Application Reference: 6/2022/1084/COND

Proposed development at: Campus West The Campus Welwyn Garden City AL8 6BX

Proposal: Submission of details pursuant to condition 9 (sustainable energy) ,10 (car charging points) ,11 (CCTV) ,12 (privacy screens) ,13 (landscaping) and 14 (materials) on planning permission 6/2021/2207/MAJ

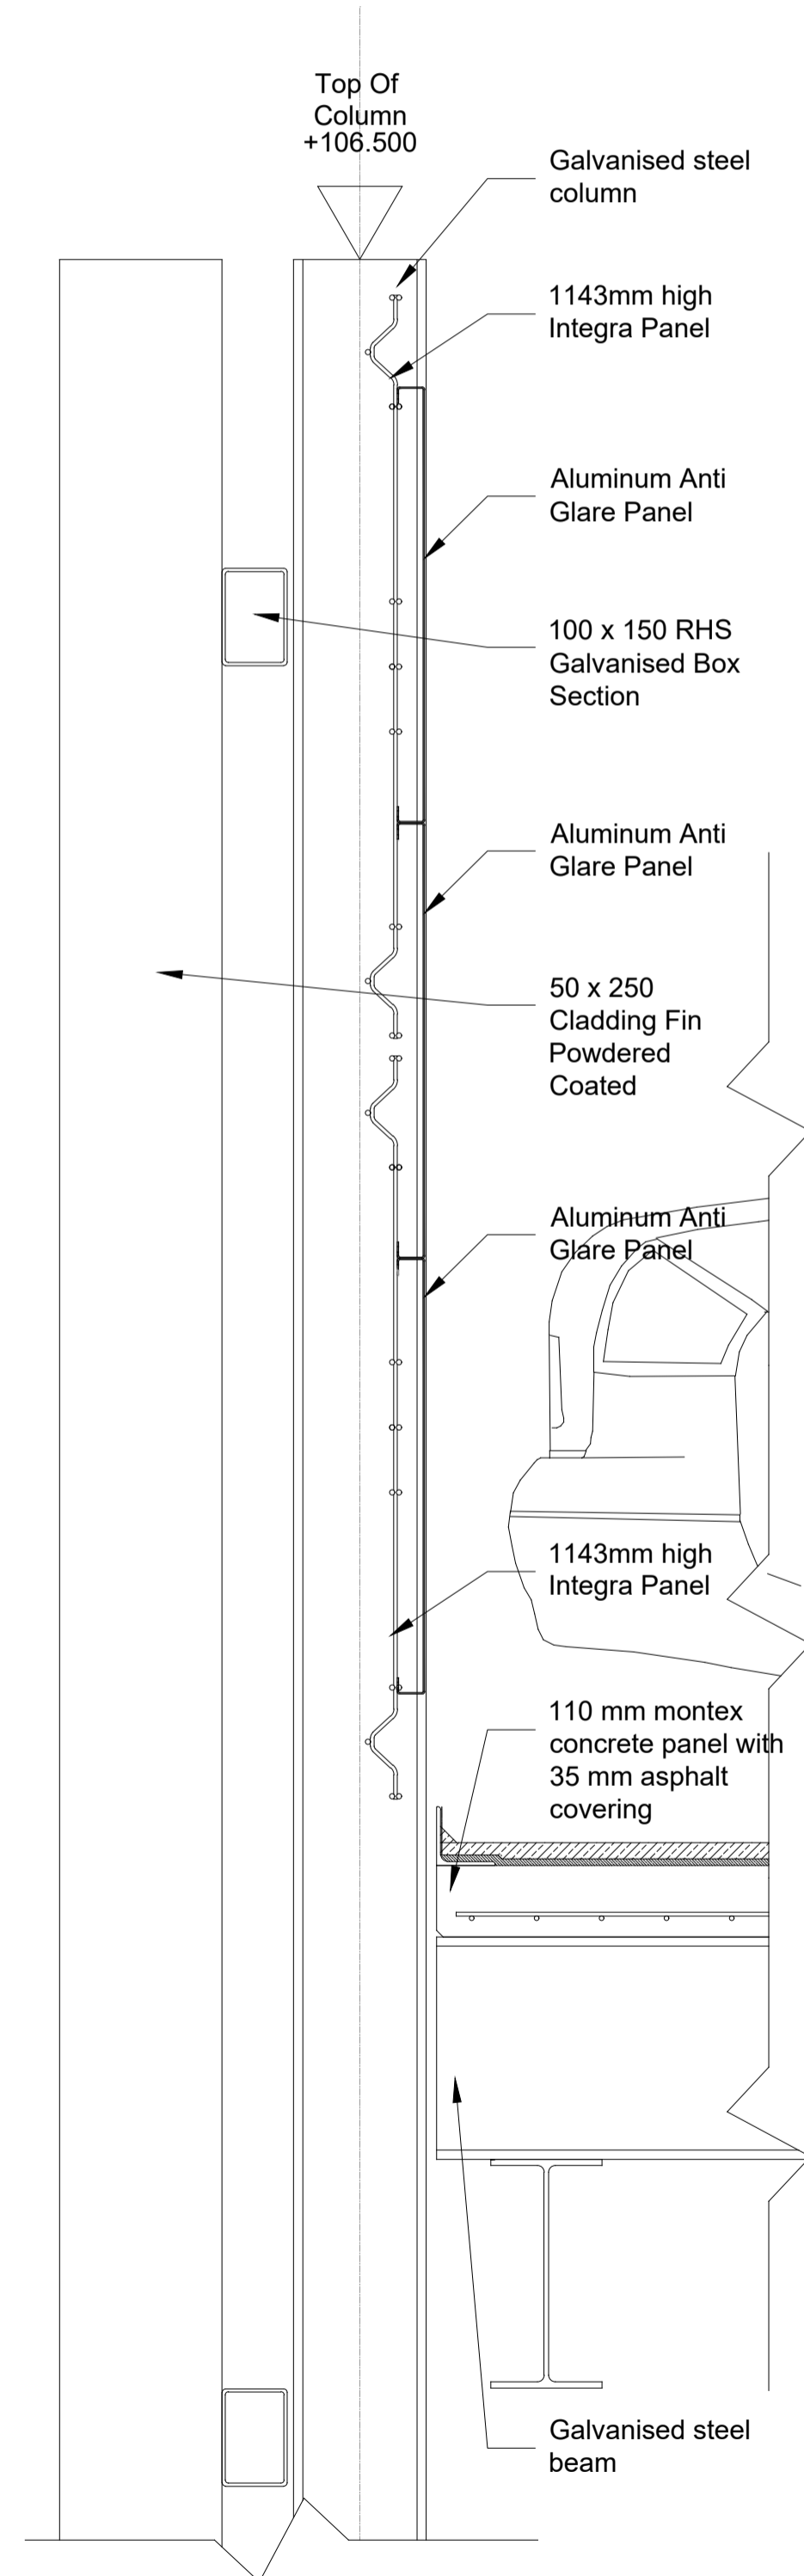
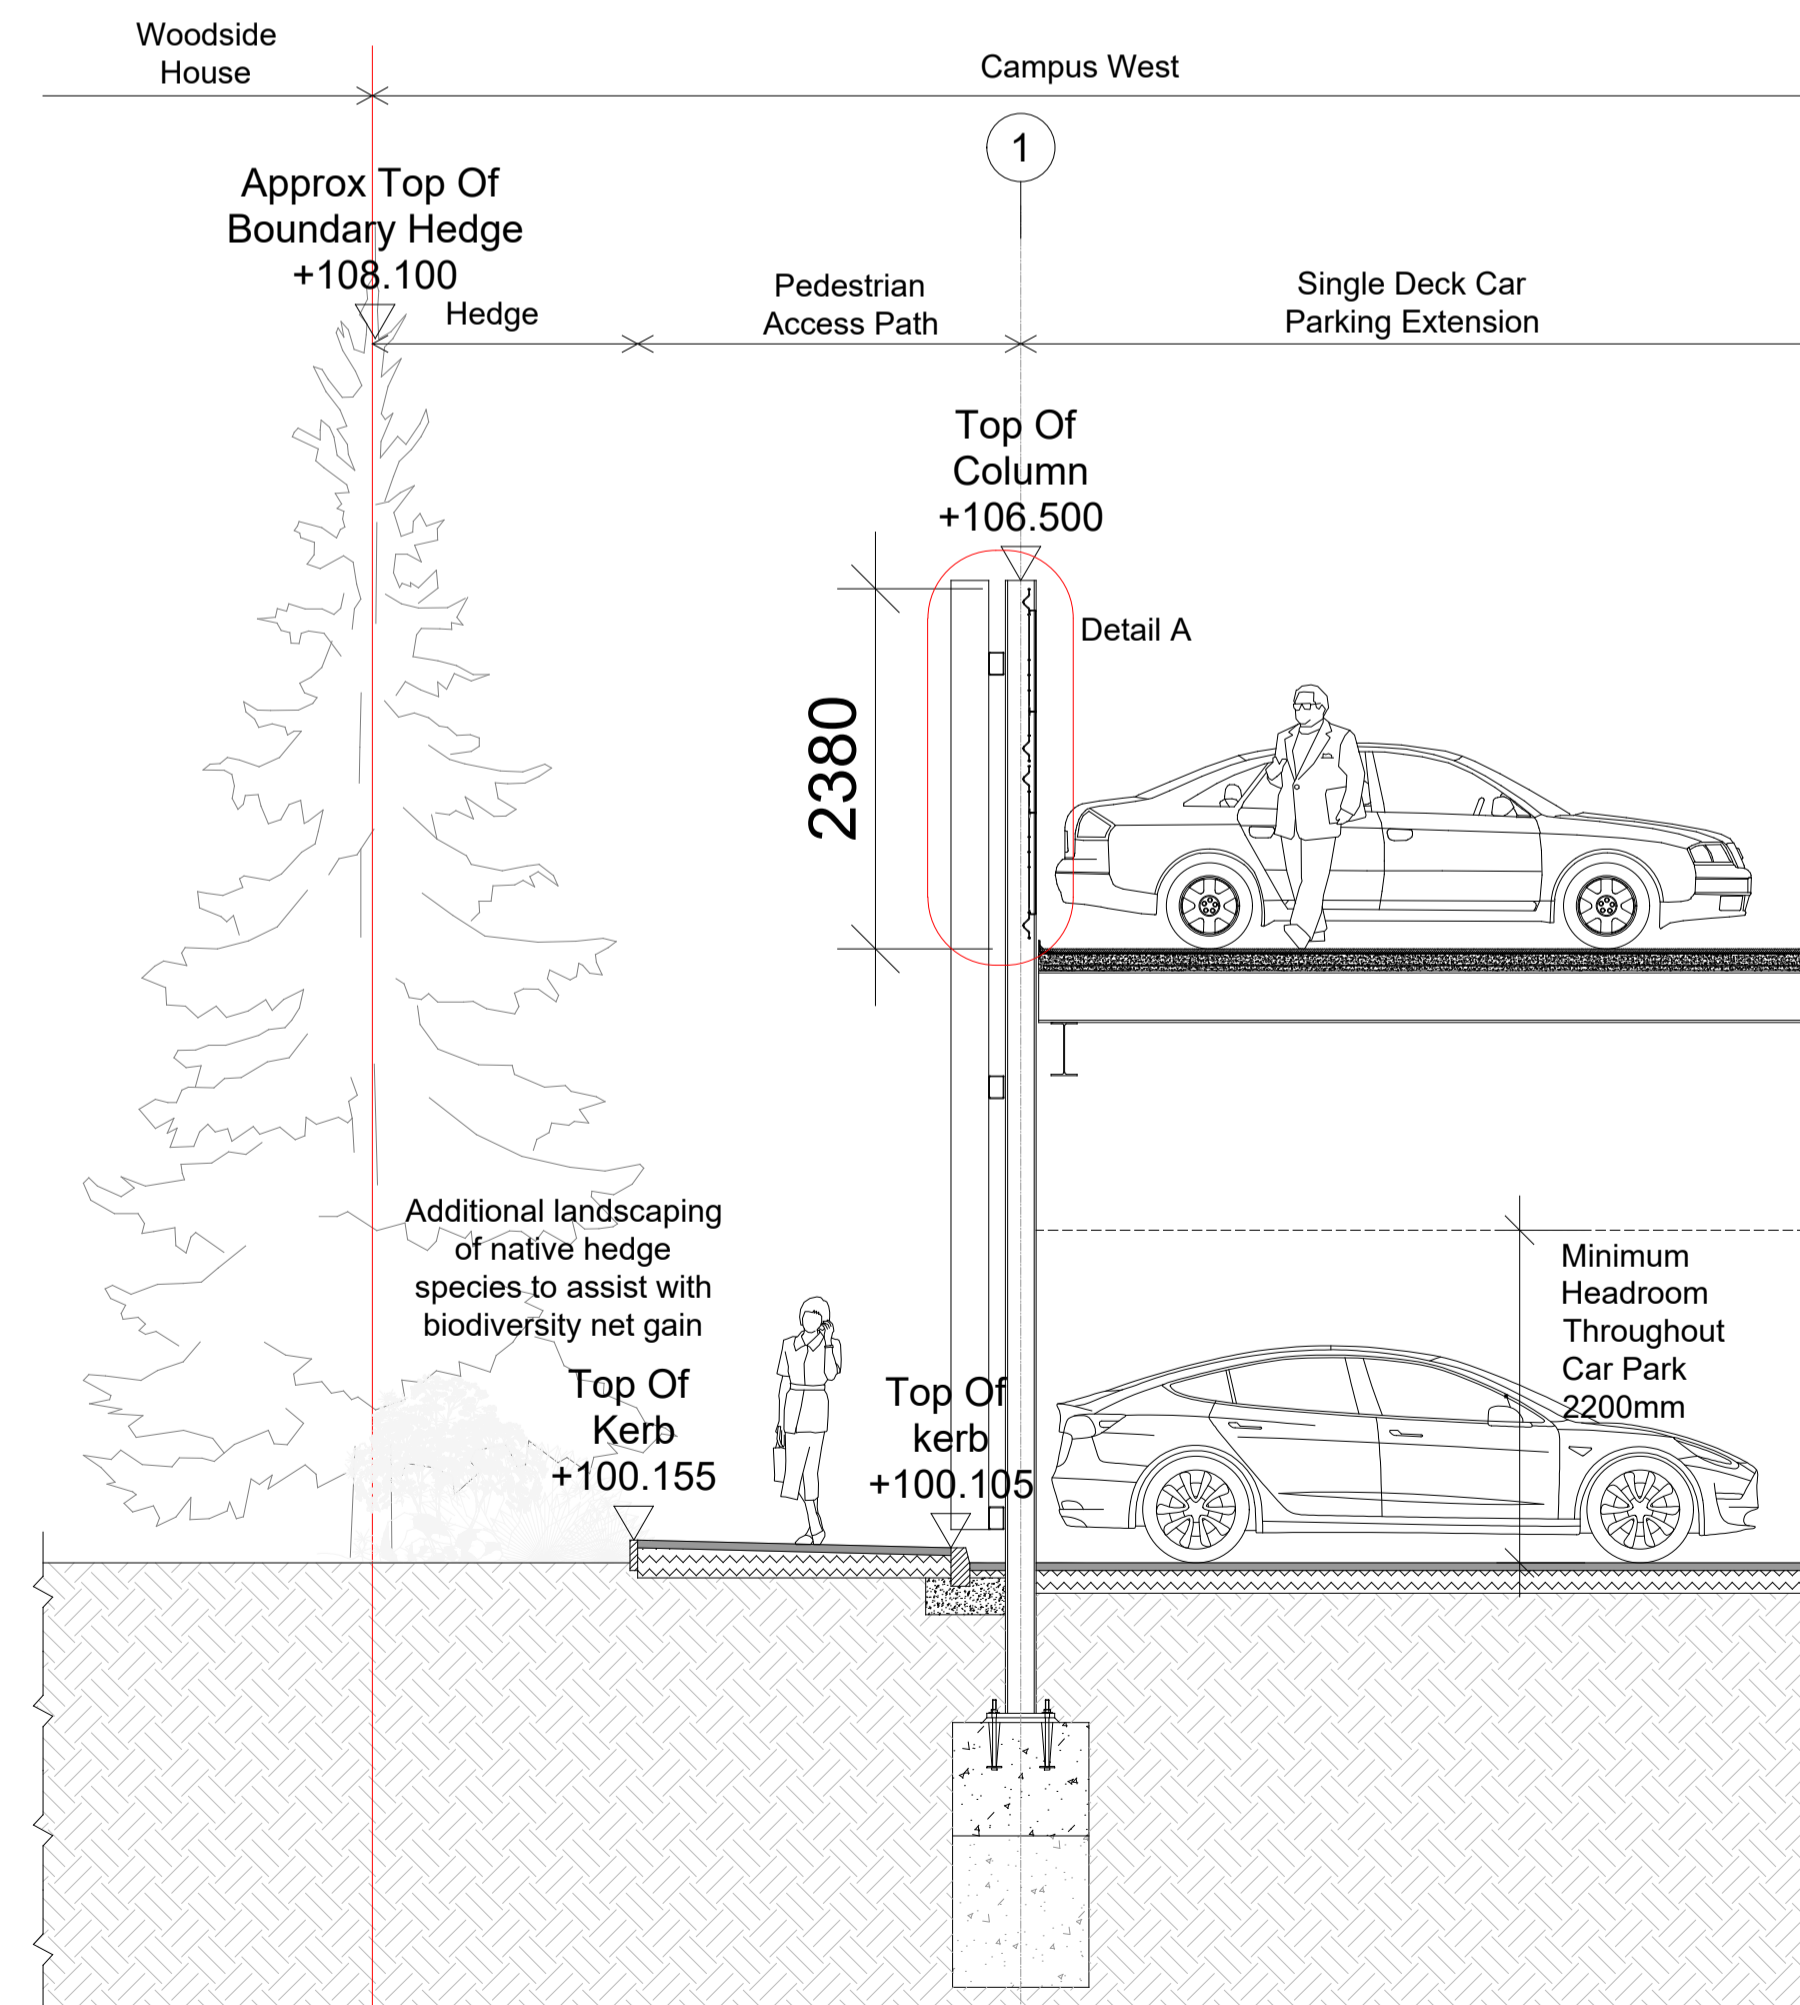
The proposed privacy screens on the western elevation of the upper deck is shown on the plans as being over 2 metres tall which, along with the existing and proposed planting on the boundaries, is considered sufficient to maintain the privacy of the adjoining residents. I can therefore confirm that sufficient information has been submitted pursuant to the requirements of condition 12. Please note that the privacy screening must be implemented as approved prior to the first use of the development.
